BURTON ENGINEERS, INC.

November 9, 1988

Re: Your letter - October 17, 1988

We are re-submitting the Drainage Plan sent to you on September 30, 1988 with the area of the roof drained to the drop inlet shown.

GRADING AND DRAINAGE PLAN
FOR NEW PARKING LOT
EL BUEN SAMARITANO
UNITED METHODIST CHURCH
(7TH STREET N.W. & GRANITE AVENUE N.W.)
ALBUQUERQUE, NEW MEXICO
DECEMBER, 1988

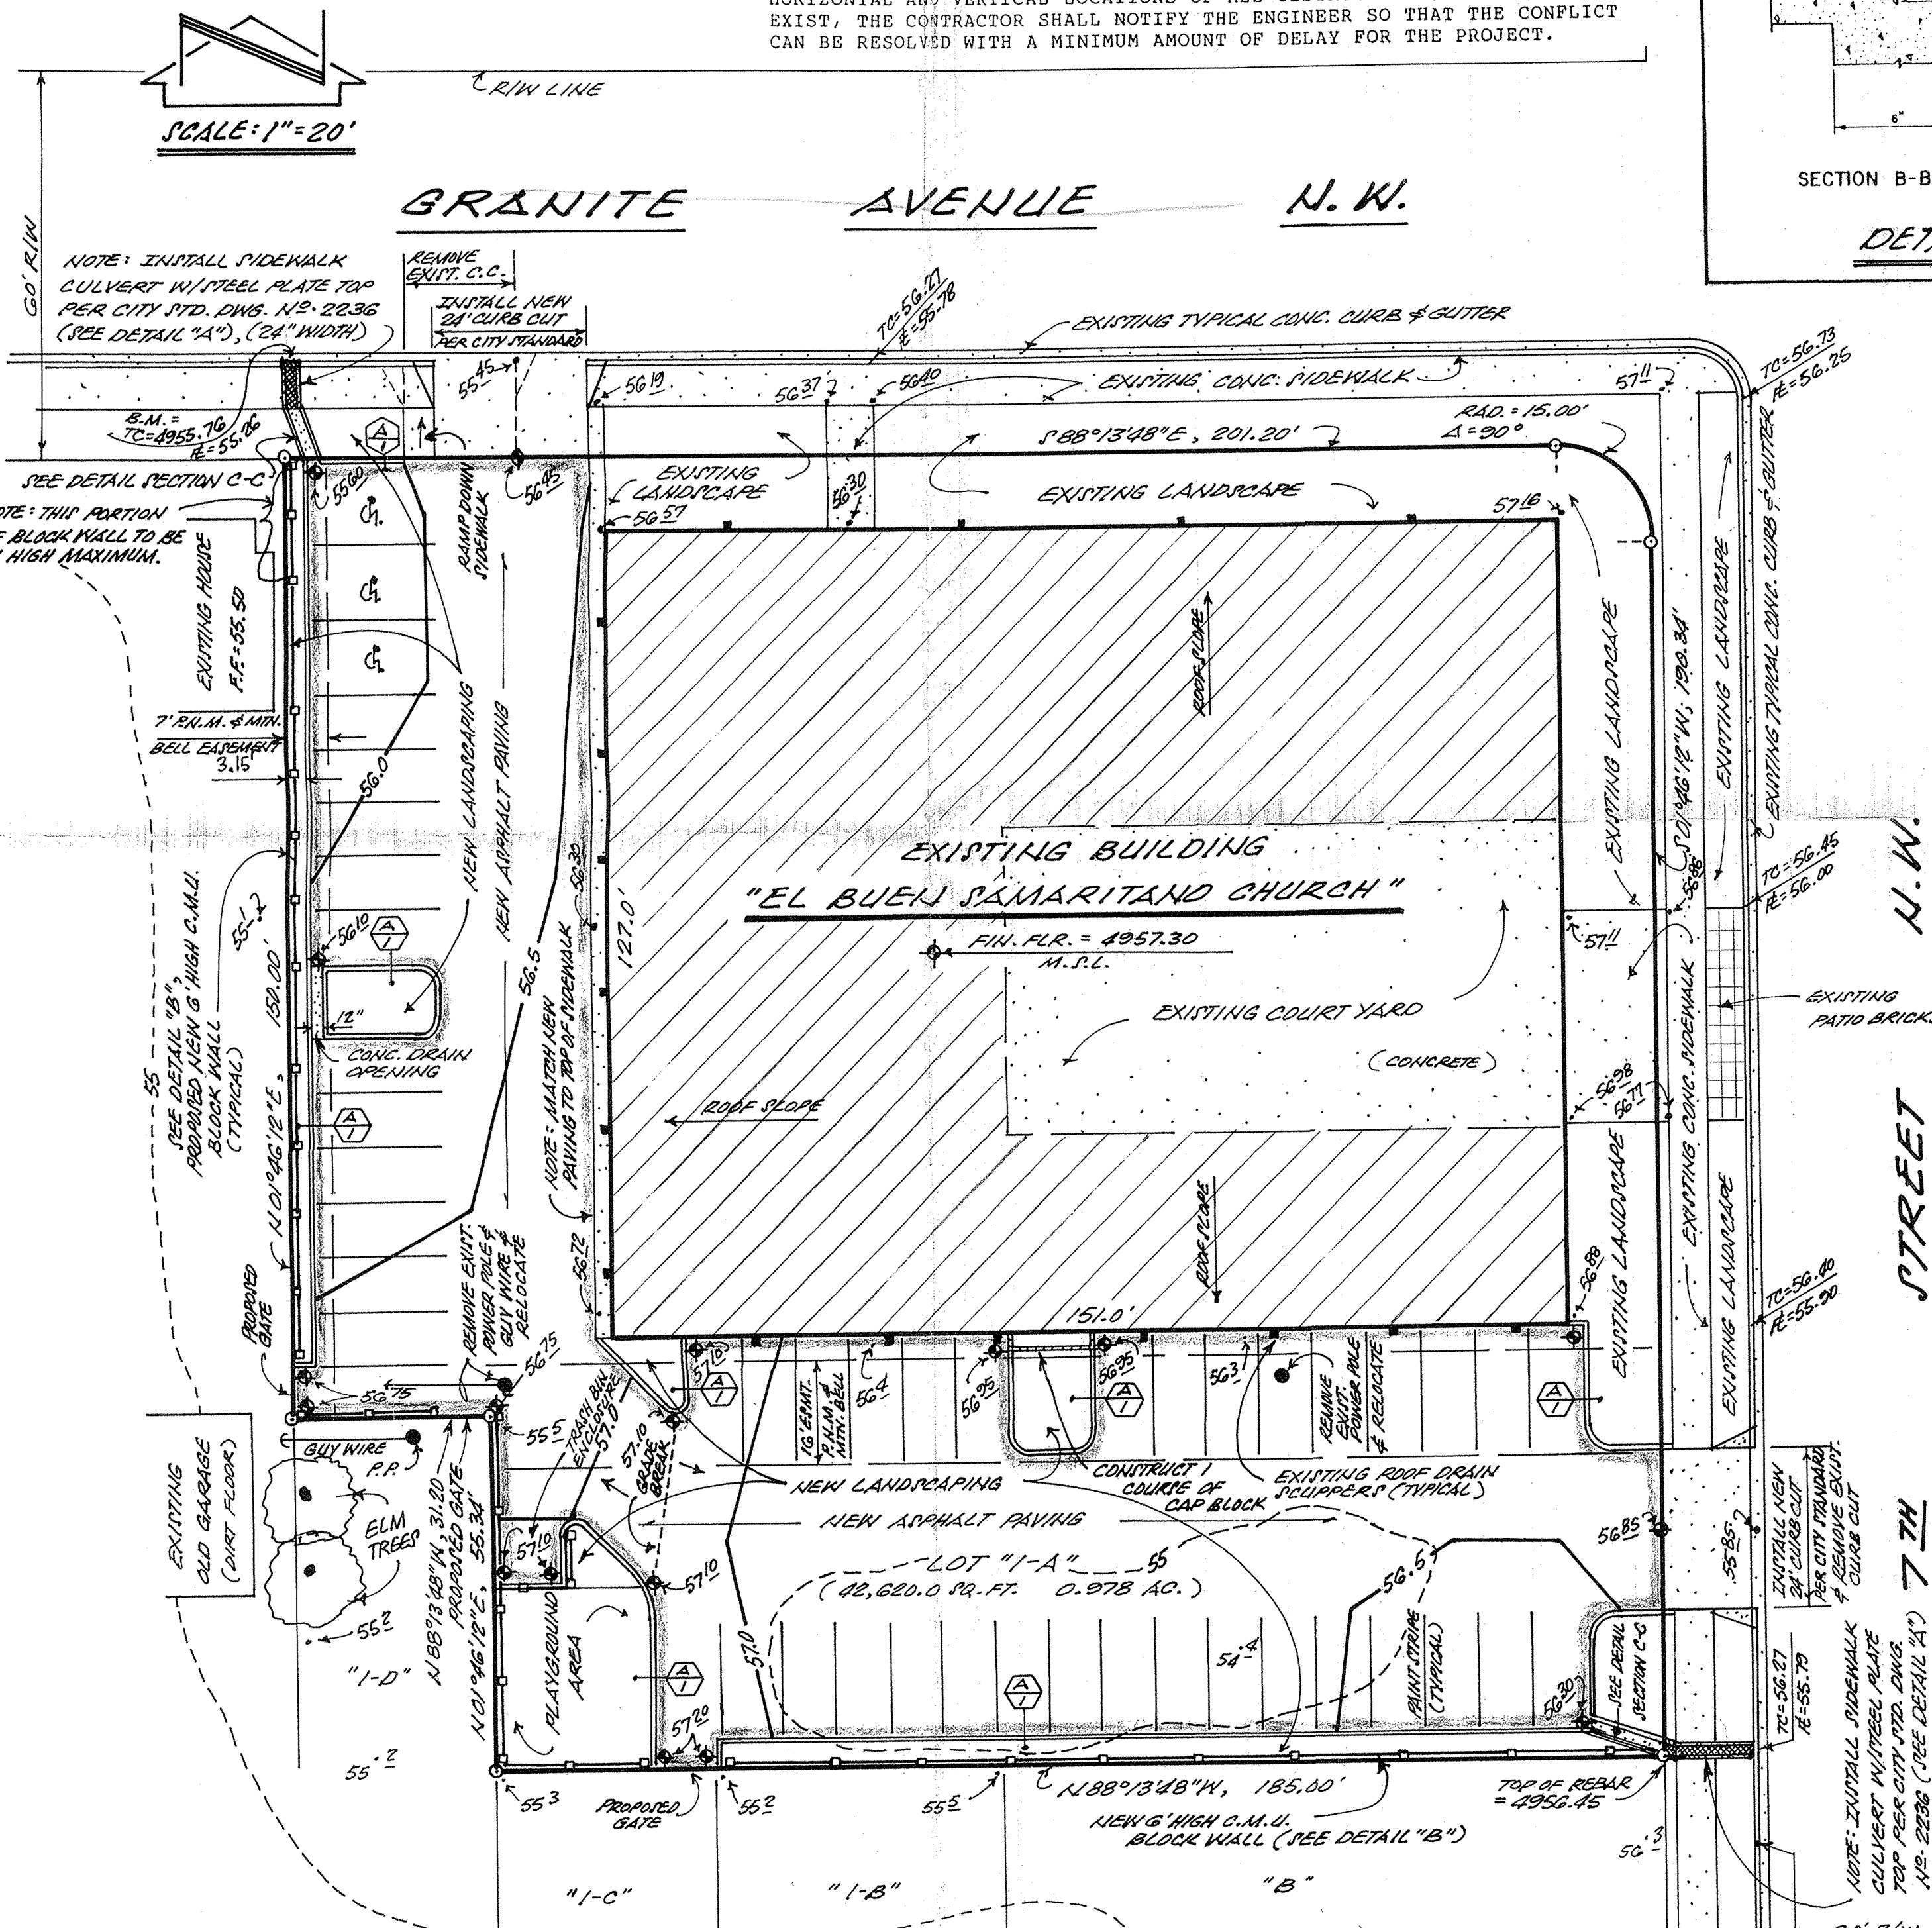
- 1) Indicate 100 year Water Surface - There is no 100 year flood surface to indicate. FIRM Map 0028C shows that the 100 year flood does not include this area. The flooded area is from 6th Street to west of the Rio Grande for a 500 year flood.

- 2) Apparently we failed to make our calculations clear. The calculations are based on a per square foot capacity. The area of the inlet is 8 sq. ft. and far exceeds the maximum flood in the parking lot. DPM Manual 2, Page 74 shows this type of inlet to have a capacity of 3.5 cfs with a submergence of 0.5'. The maximum submergence without flooding other areas is 1'.

- 3) Invert of the inlet on the plans is 49.42'. Invert of the pipe is 49.21' at the manhole.
- 4) The roof drains for the roof area that is diverted to the drop inlet are equally spaced along the south and west sides of the building. We have shown flow arrows on the plan sheet.
